TfNSW reference: STH25/00160/002

Your reference: SSD-76440958

SSD-76440958 – MIXED USE DEVELOPMENT WITH INFILL AFFORDABLE HOUSING – PUBLIC AUTHORITY CONSULTATION – 221 TO 291 CROWN STREET, 216 TO 238 KEIRA STREET AND 86 TO 90 BURELLI STREET, WOLLONGONG

Attachment 1

ROAD LONGITUDINAL SECTION ALONG DRIVEWAY 2 LEFT EDGE CONTROL LINE
SCALE H:1in100 V:1in100

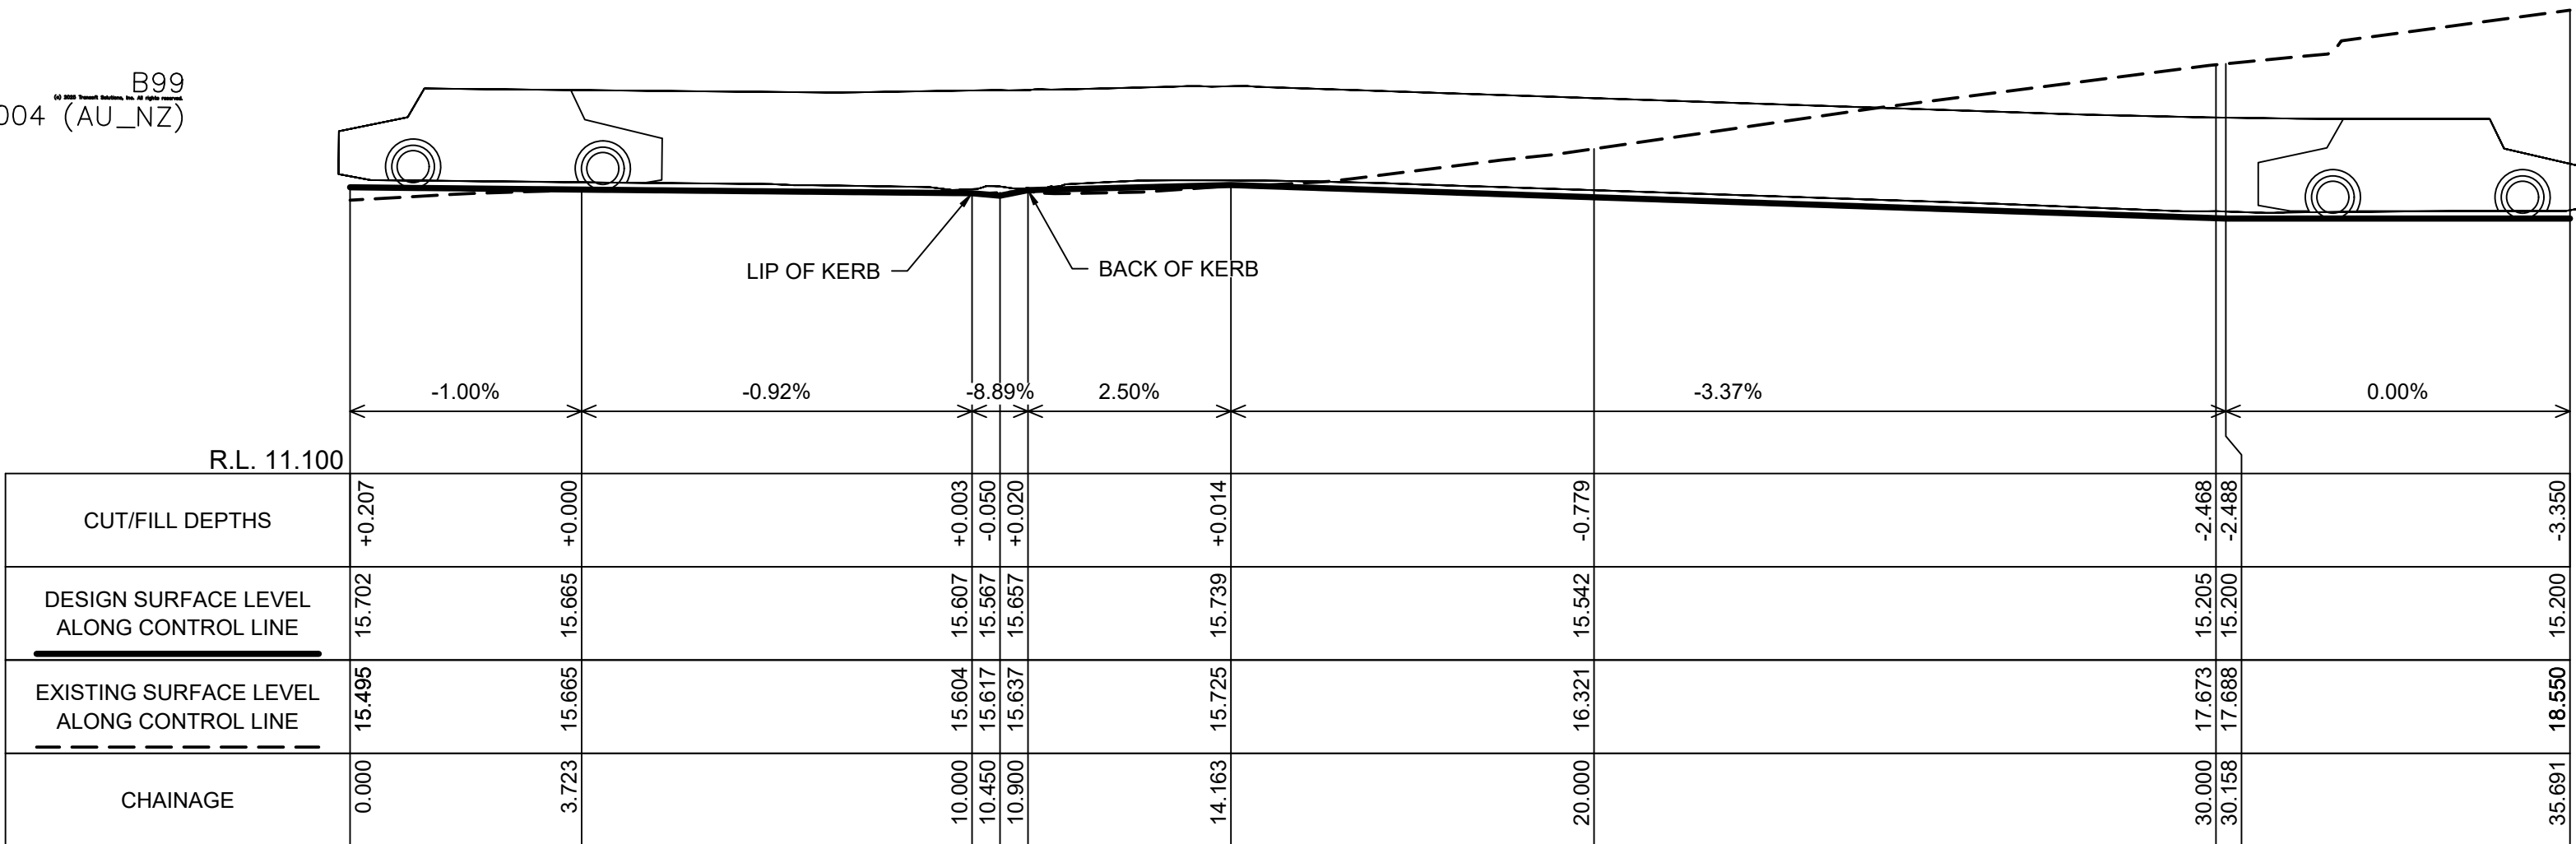
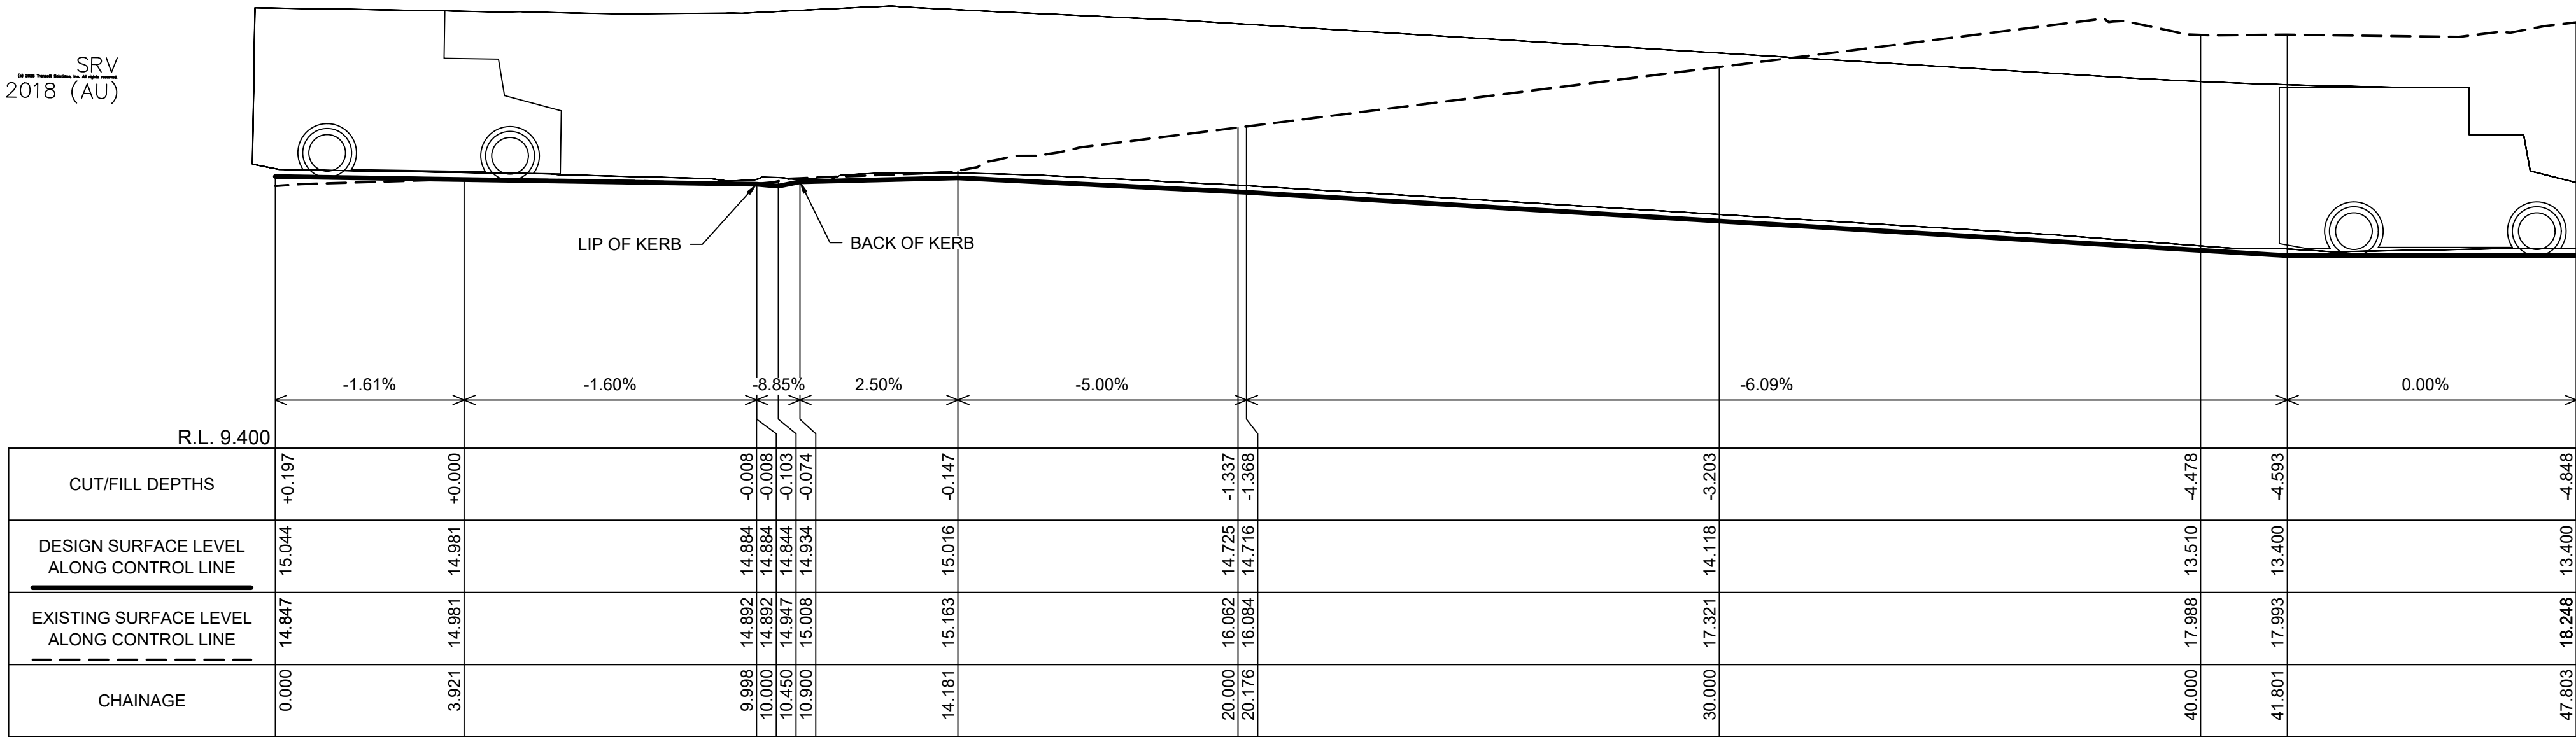
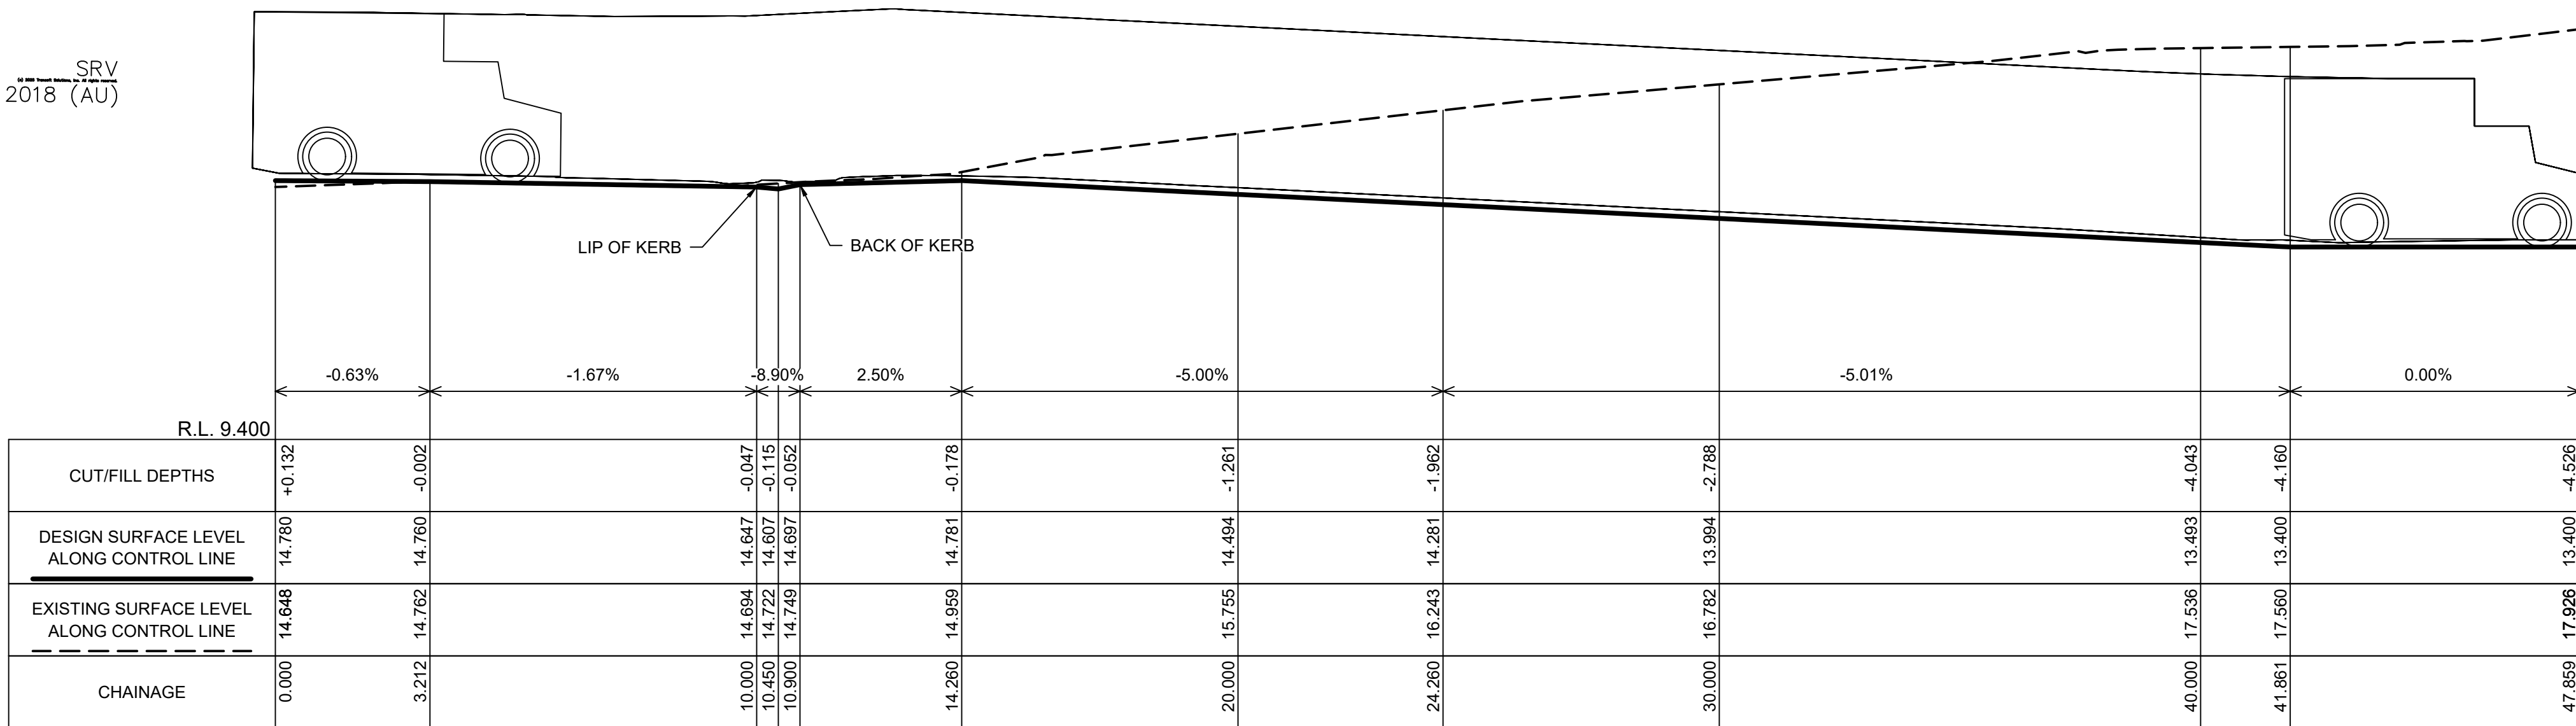
- b) Swept paths: TfNSW notes that the swept path analysis for service vehicle access to Burelli Street (refer to Attachment 5 in the Traffic Impact Assessment prepared by Genesis Traffic, Job No. 24179, Version 5 dated 30.07.2025) demonstrates that service vehicles are unable to enter and exit the property simultaneously. This outcome is unacceptable, as it would require service vehicles to wait within the through lane of Burelli Street. Revised designs shall be submitted showing that the largest service vehicles can enter and exit the site simultaneously, maintaining all required clearances and appropriate design speeds.

- c) Largest vehicle size: Noting the size of the development, the mix of uses and the change of occupiers that will occur over time, further justification is required on why a swept path for a 17.5m semi-trailer has been used as opposed to a 19m semi-trailer.
